STATE OF NORTH CAROLINA
DEPARTMENT OF TRANSPORTATION

Addendum No. 2

RE: Contract # C204107

Cumberland County (U-4405)

PROJECT REFERENCE NO.	U-4405	SHEET NO.	UC-10
DESIGNED BY:	AMH		
DRAWN BY:	AMH/AB		
CHECKED BY:	AMH		
APPROVED BY:	MWF		
REVISED:		6/12/2018	
UTILITIES ENGINEERING SEC. PHONE: (919) 707-6696 FAX: (919) 250-4751

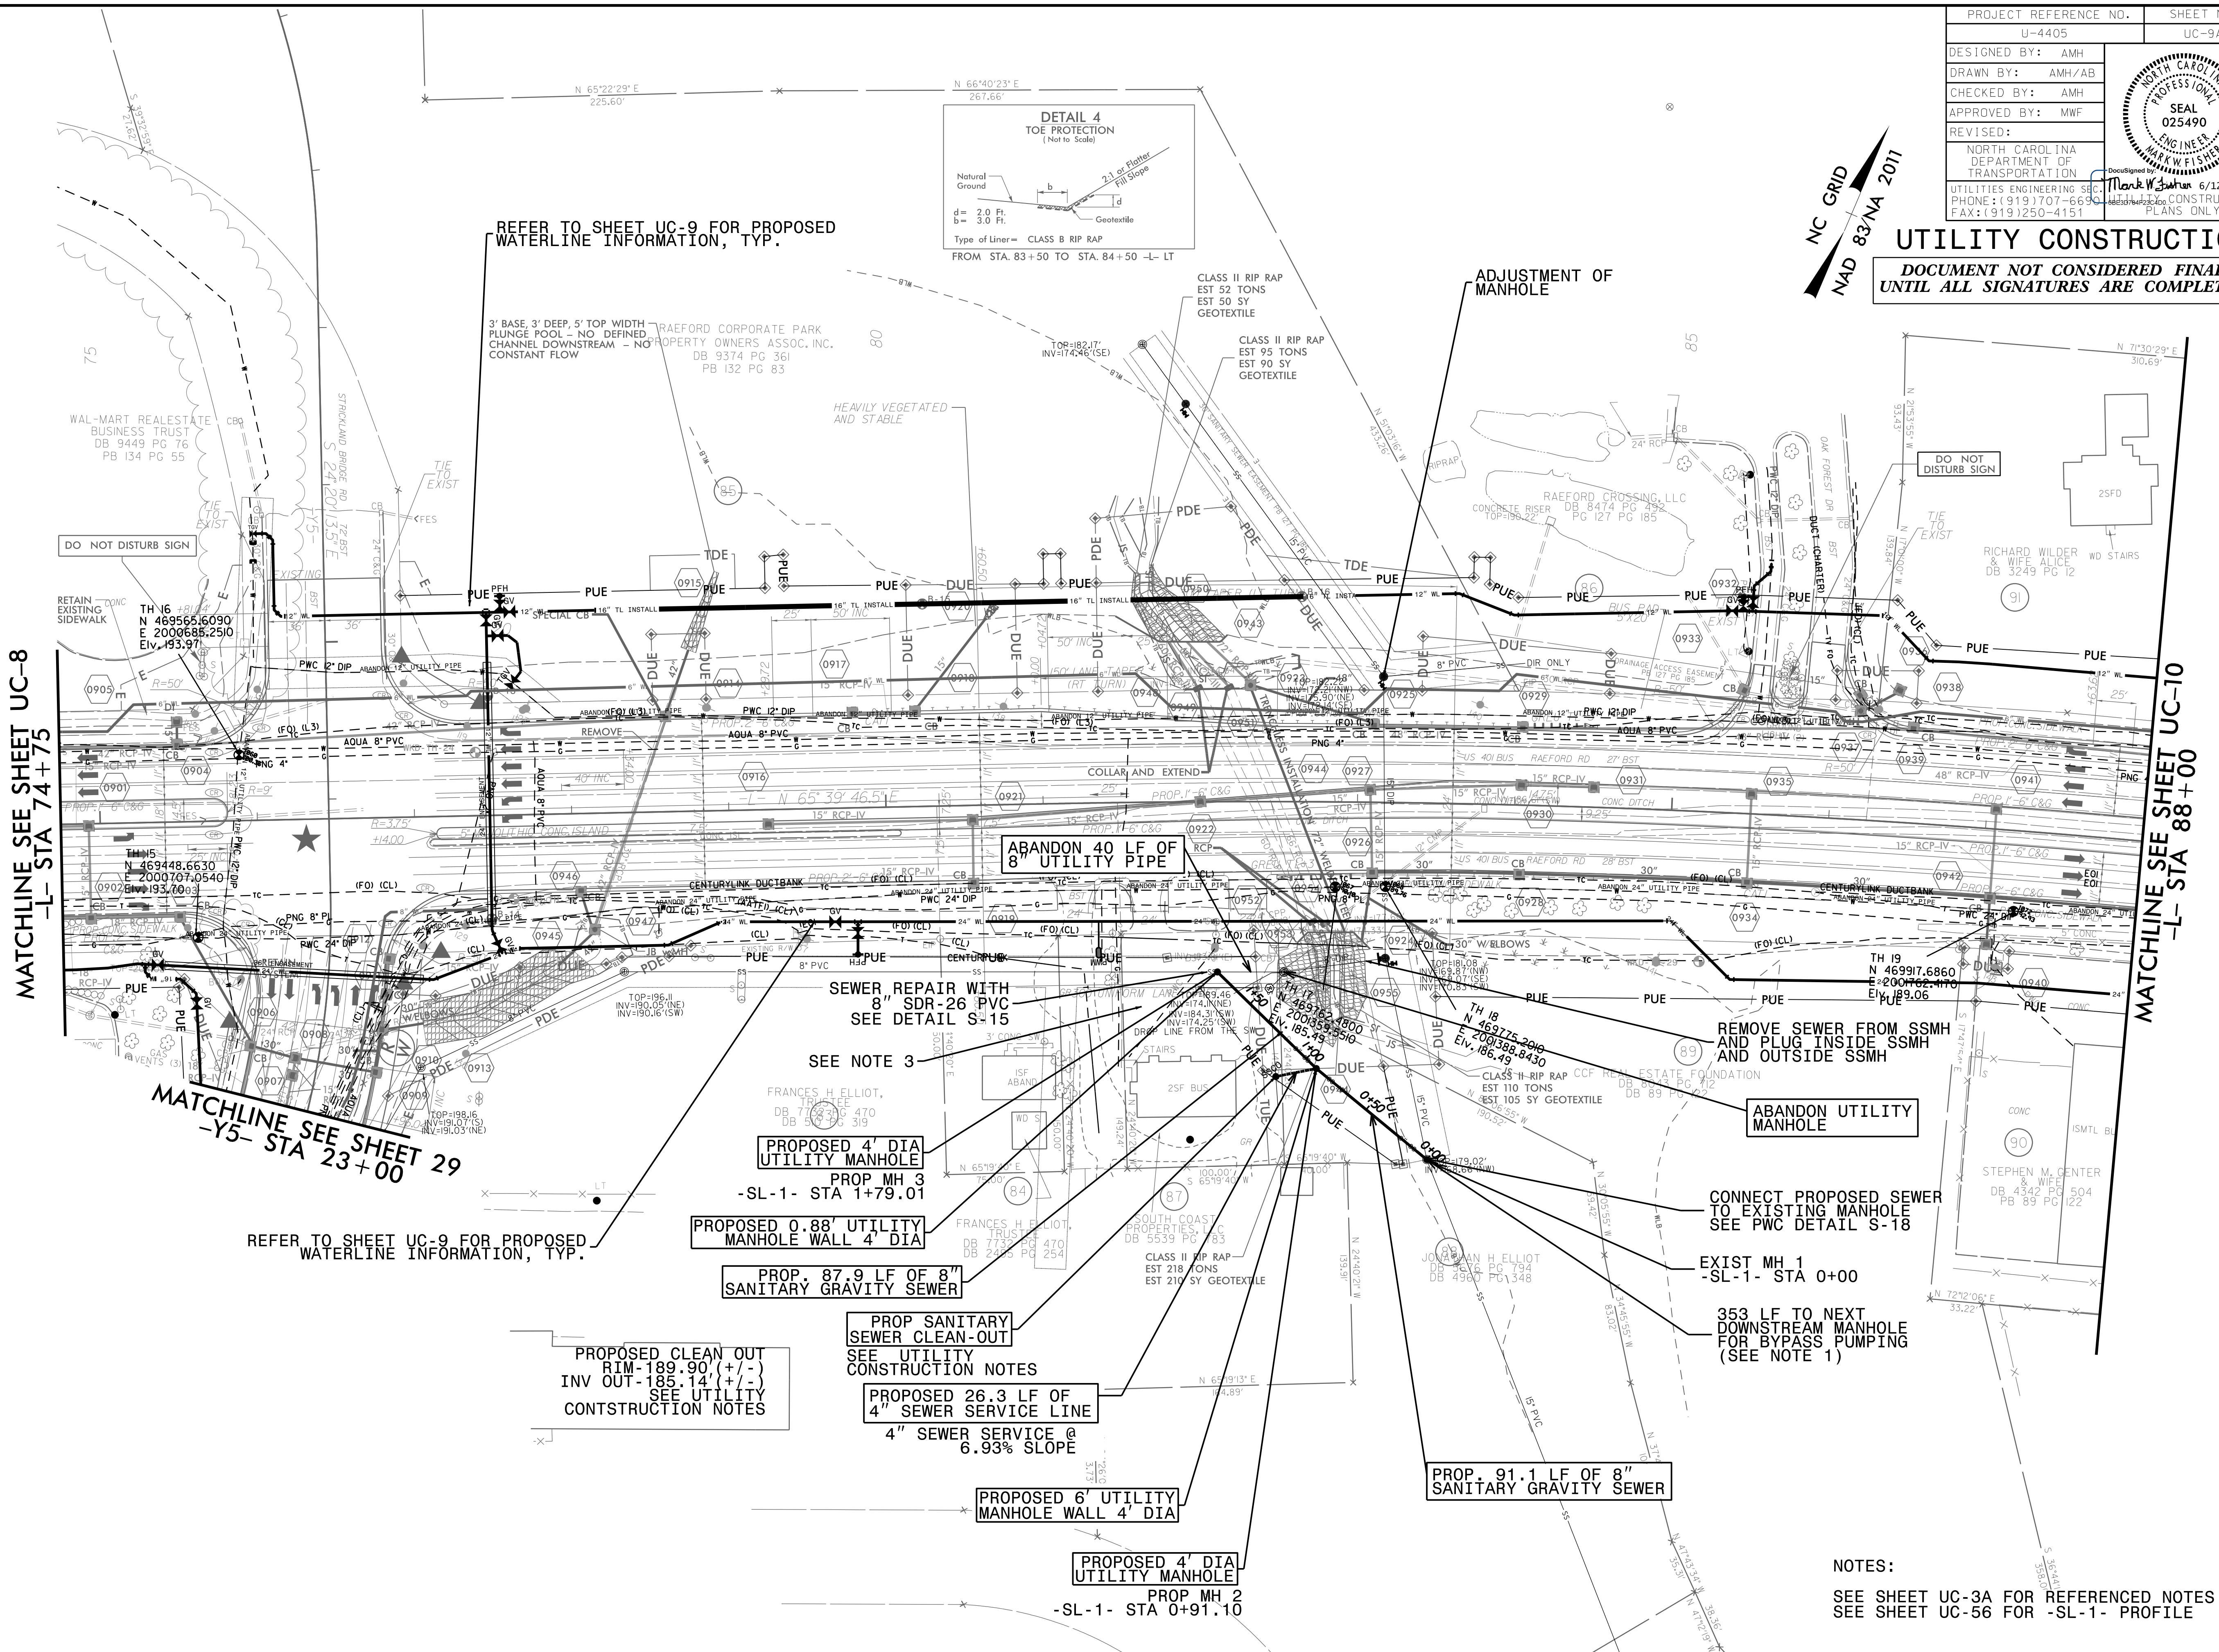
UC-3I thru UC-3Q	Added details W.1, W.2, W.3 and W.4; revised all references from "FAYPWC" to "Engineer" and all specification references to "Utility Special Provisions"; revised or added notes on UC-3Q to Stream Pump Around detail and Cofferdam detail
UC-9	Revised the thickness on the 24" and 36" encasement
UC-10	Revised encasement thicknesses and corrected WL alignment name at WL-13 Sta. 24+58.94
UC-13	Moved fire hydrant on WL-14 to branch off new 6" water line. Changed 2" waterline and encasement length. Changed 30" HDPE SDR 11 to 32" HDPE SDR9
UC-14	Added labels to existing valves for construction sequencing
UC-15	Shifted valve on WL-18 to Sta. 8+00 so hydrant may be used for flushing point
UC-16	Increased font size of profile sheet references in bottom right corner
UC-17	Added the following: alignment label in plan view for WL-20A; a sanitary sewer service reconnection on Karr Drive for Parcel 23; labels to existing valves for construction sequencing; note to remove valve to start of WL-19 and a 12" line stop in front of Circle K gas station

PROJECT REFERENCE NO.	SHEET NO.
U-4405	UC-18
DESIGNED BY: AMH	
DRAWN BY: AMH/AB	
CHECKED BY: AMH	
APPROVED BY: MWF	
REVISED:	
NORTH CAROLINA DEPARTMENT OF TRANSPORTATION UTILITIES ENGINEERING SECTION PHONE: (919) 707-6690 FAX: (919) 250-4151

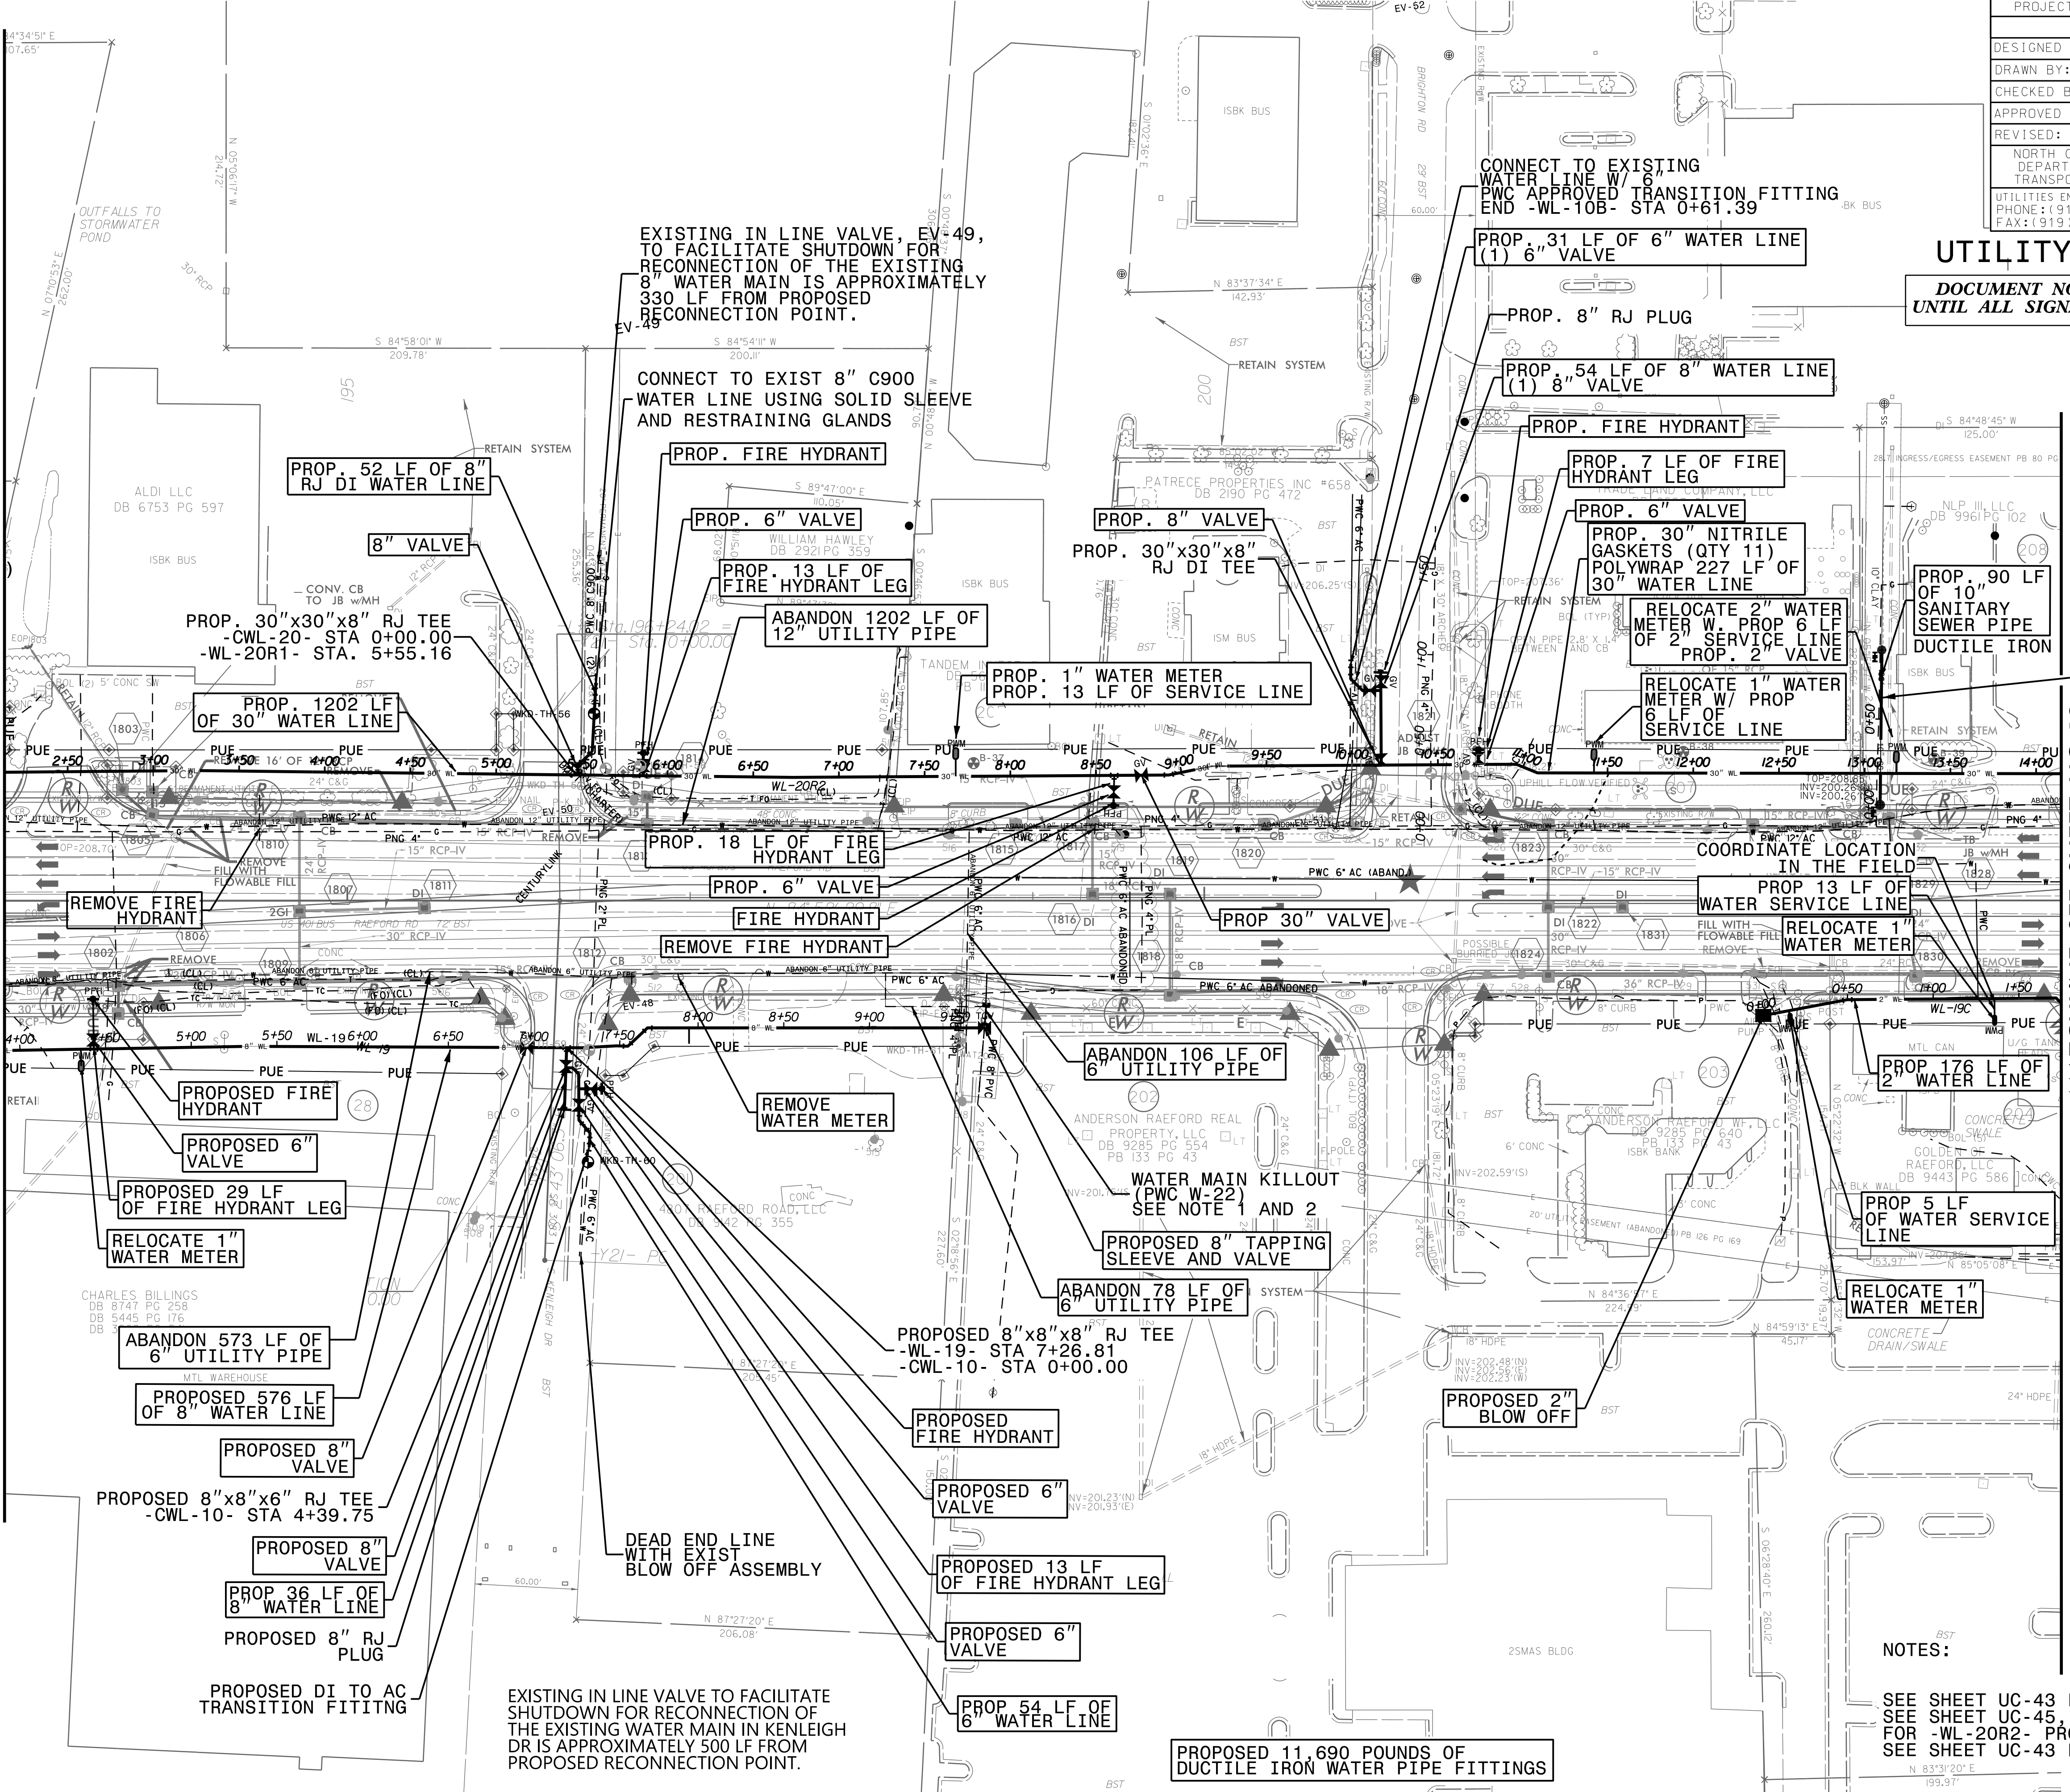
UC-18	Added labels to existing valves for construction sequencing
UC-19	Added labels to existing valves for construction sequencing; added temporary 1" service line for Parcel 227; shifted valve on WL-19 to Station 8+24 and moved water meter and hydrant inside of PUE on Parcel 214
UC-20	Added temporary 1" service line for Parcel 227; shifted water meter and service line for Parcel 227; Added labels to existing valves for construction sequencing
UC-20A	Added "No. 11" to the callout for 100 SF of Temporary Shoring
UC-21	Revised callouts to "See Construction Notes"; shifted valve on -WL-20R2- to Sta. 53+60; added labels to existing valves for construction sequencing and added valve to base file on Faison Ave
UC-22	Added callouts for abandoned sewer lines (3 locations); added a 30" valve to -WL-20R2-; added labels to existing valves for construction sequencing and added callout referencing next-in-line valve on Ferncreek Drive
